An
Bord
Pleanála

Memorandum ABP-315708-23 Request for Further Information

To: Brendan Wyse, ADP
From: Hugh D. Morrison
Re: Proposed quarry at Magherasolis and Craigs, Raphoe, Co. Donegal
Date: 6th December 2023

Job Number 19280 Dwg Number 09

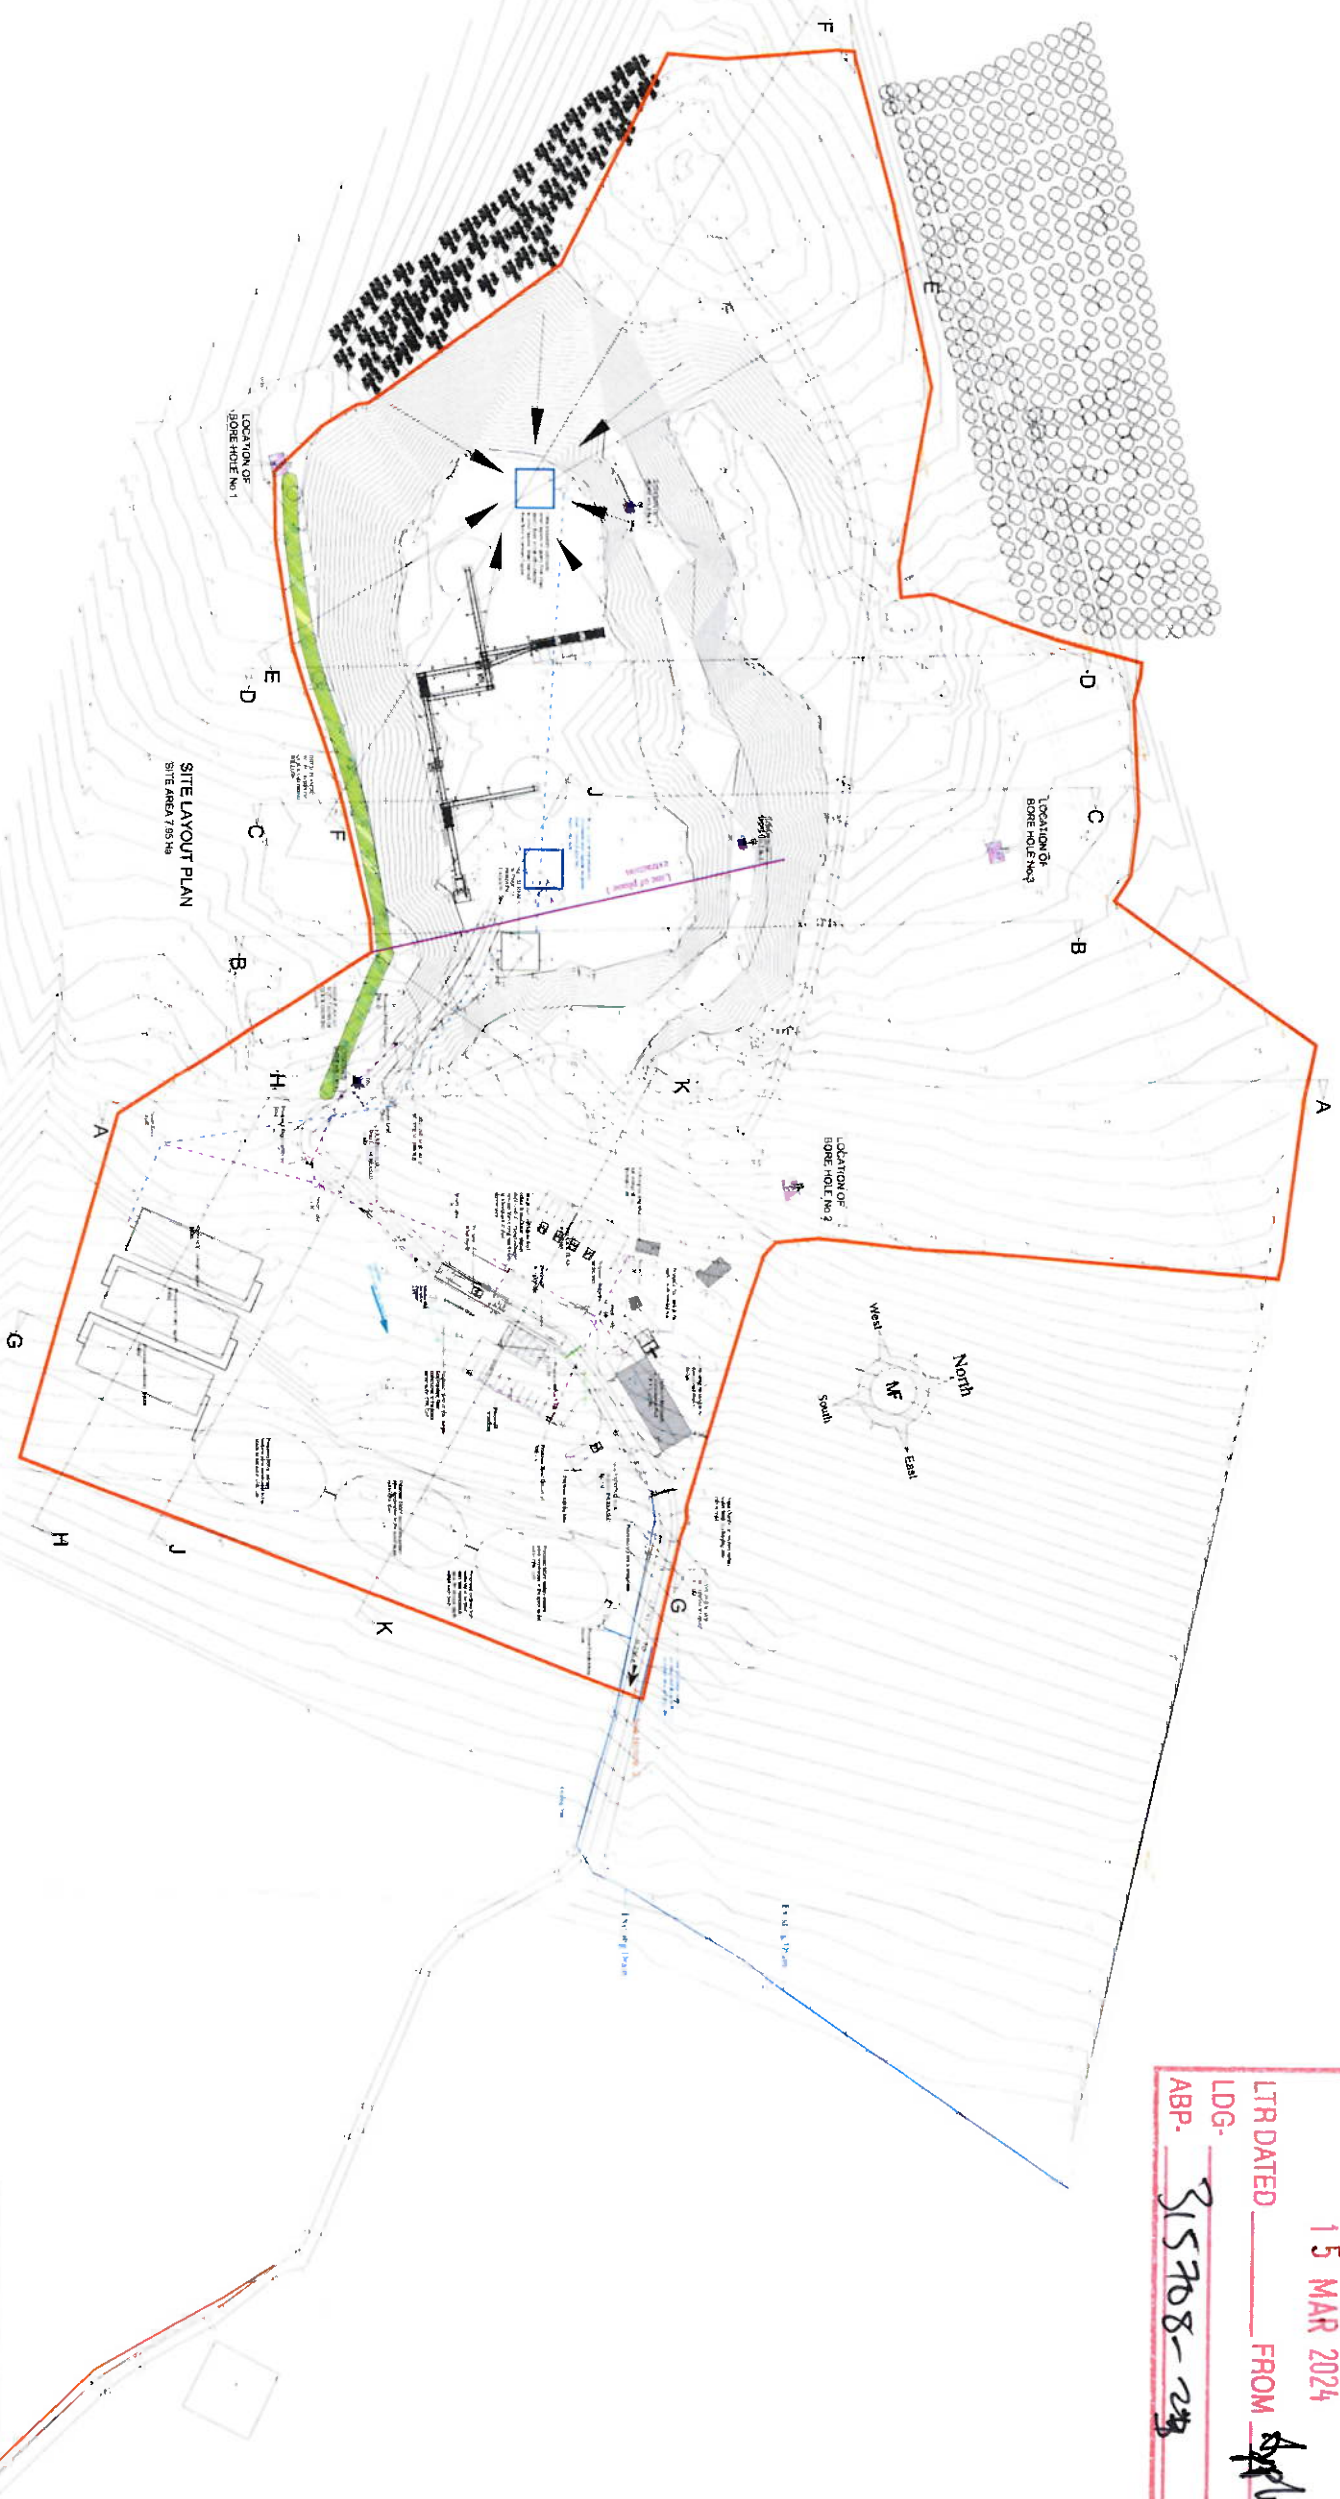
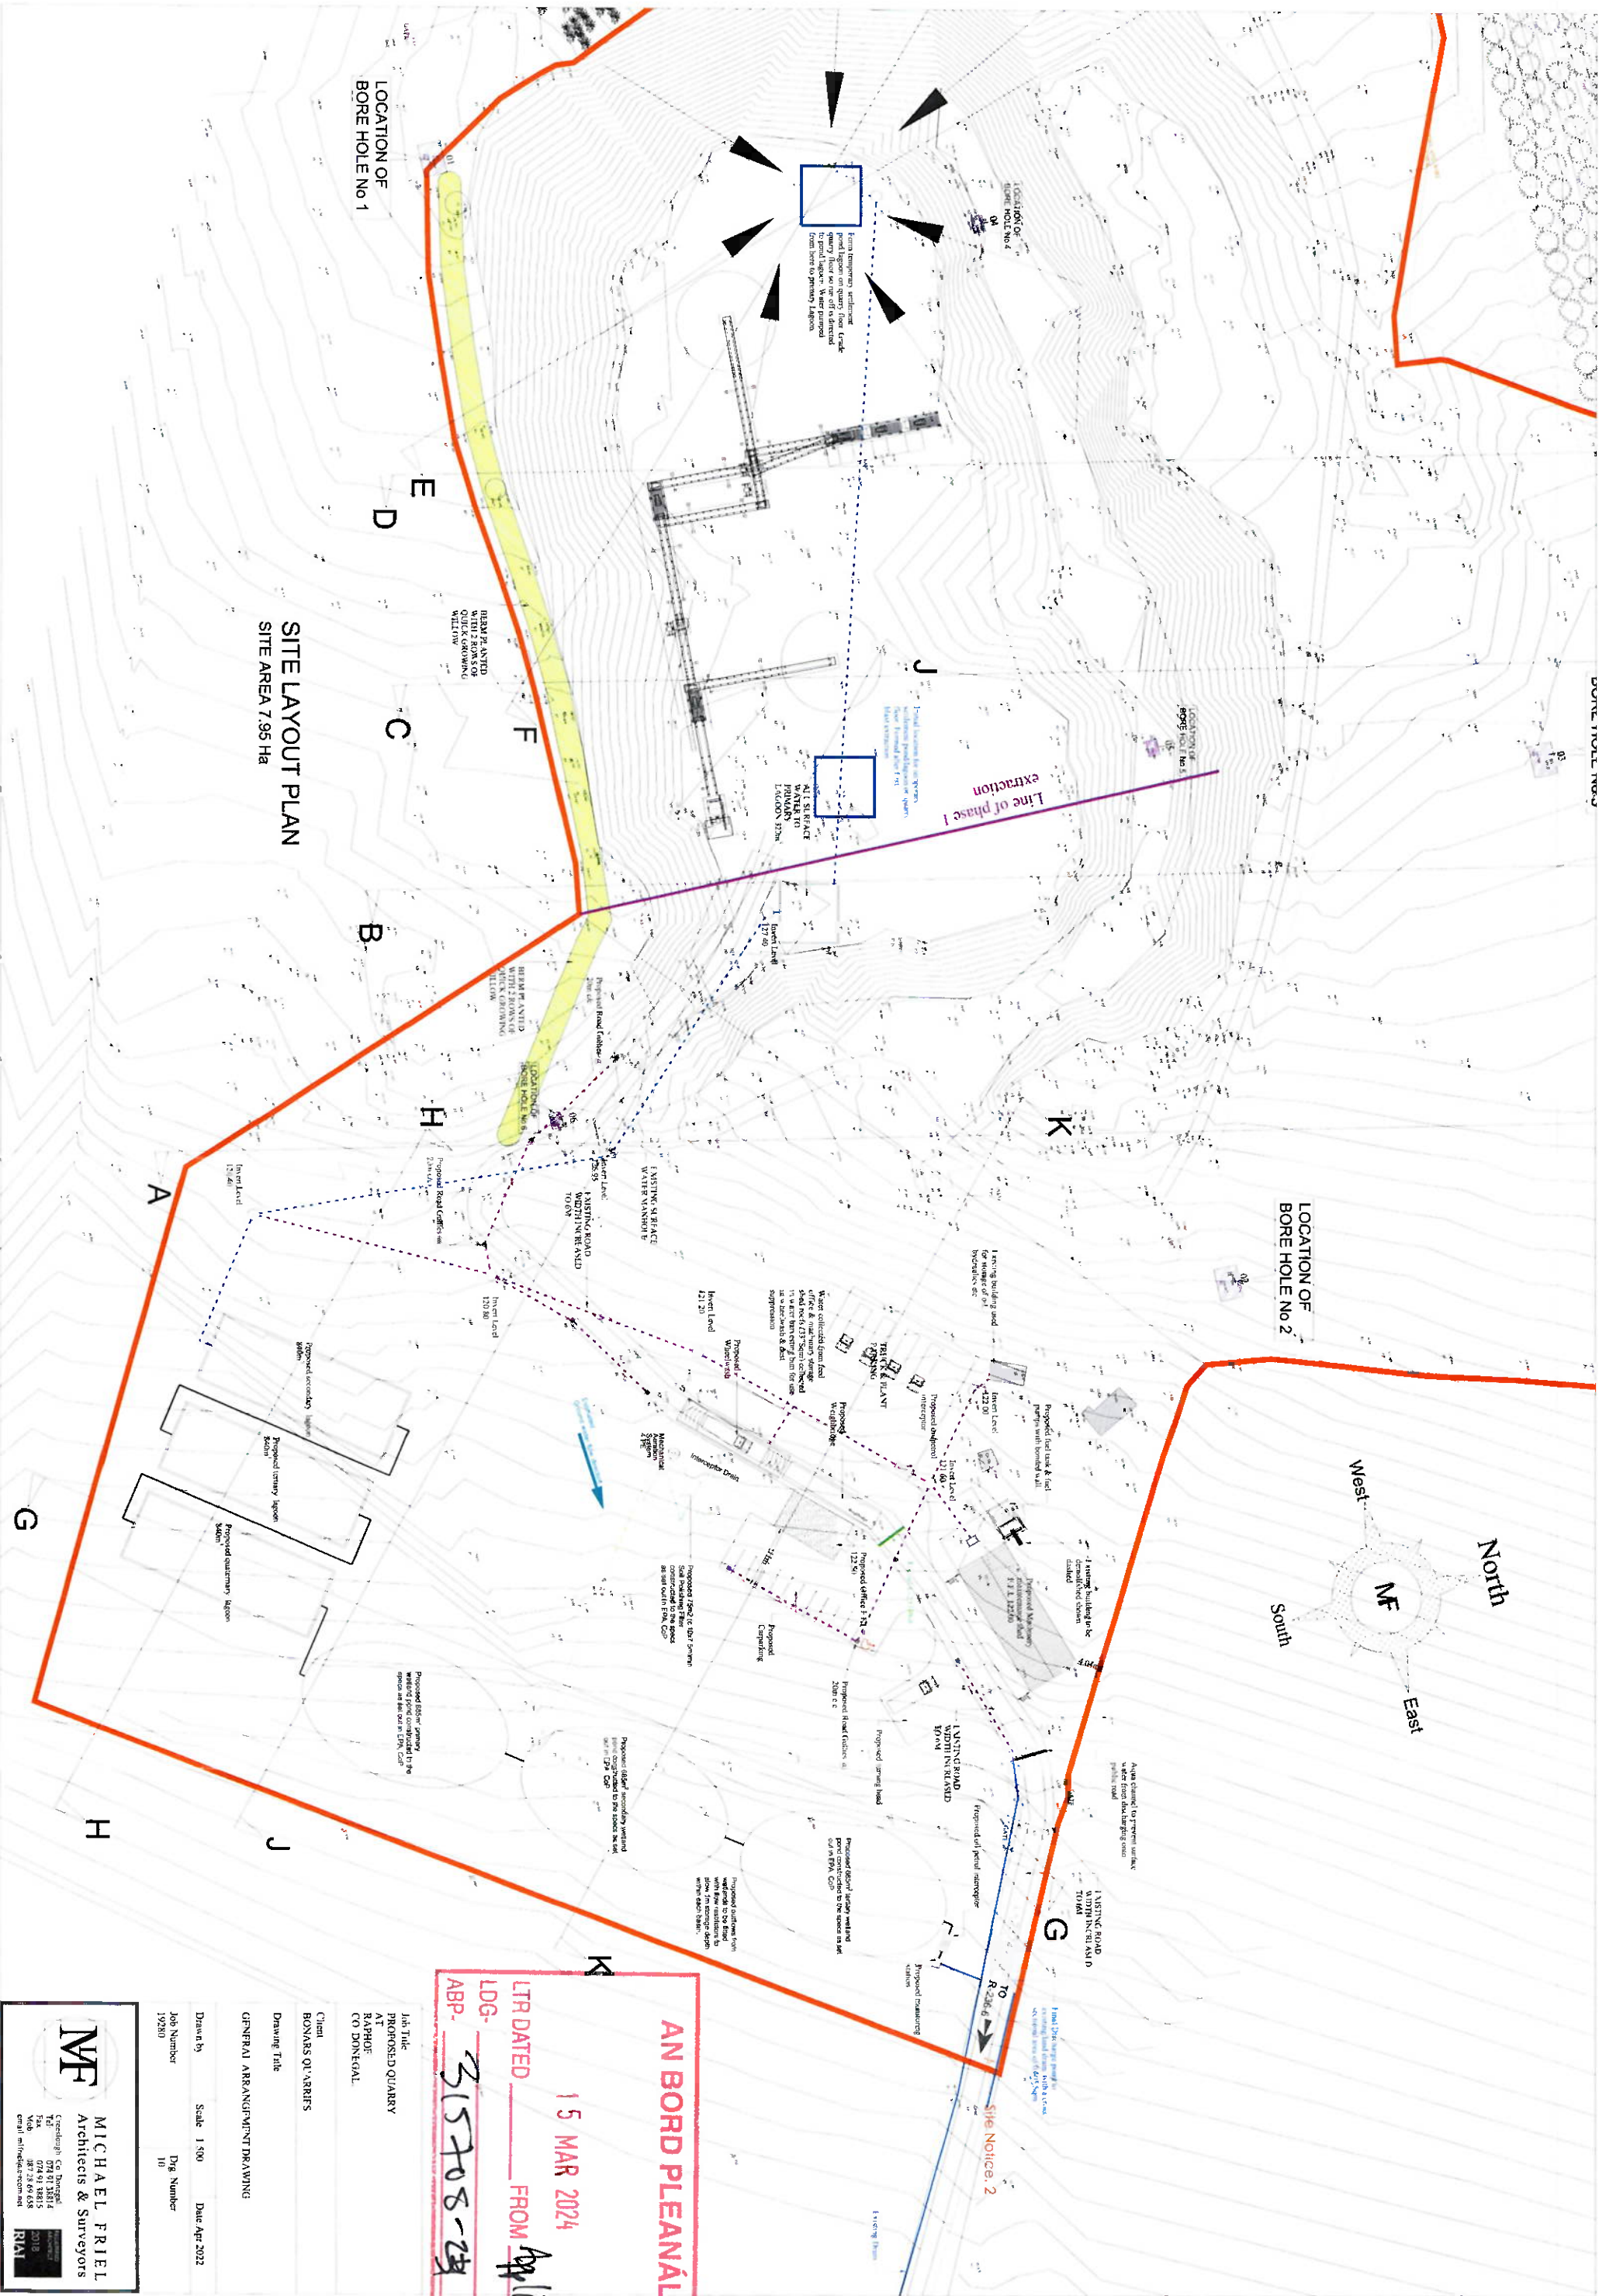
5. Please clarify the improvements proposed for the means of access to the site, i.e., the local road and its onward extension into the site, by means of a detailed site survey plan and elucidating cross-sections. This plan and these cross-sections shall indicate how the means of access would be drained and the relationship between it and the land drain, which would receive the discharge from the site. Any removal of existing vegetation to improve forward visibility shall be specified, too.
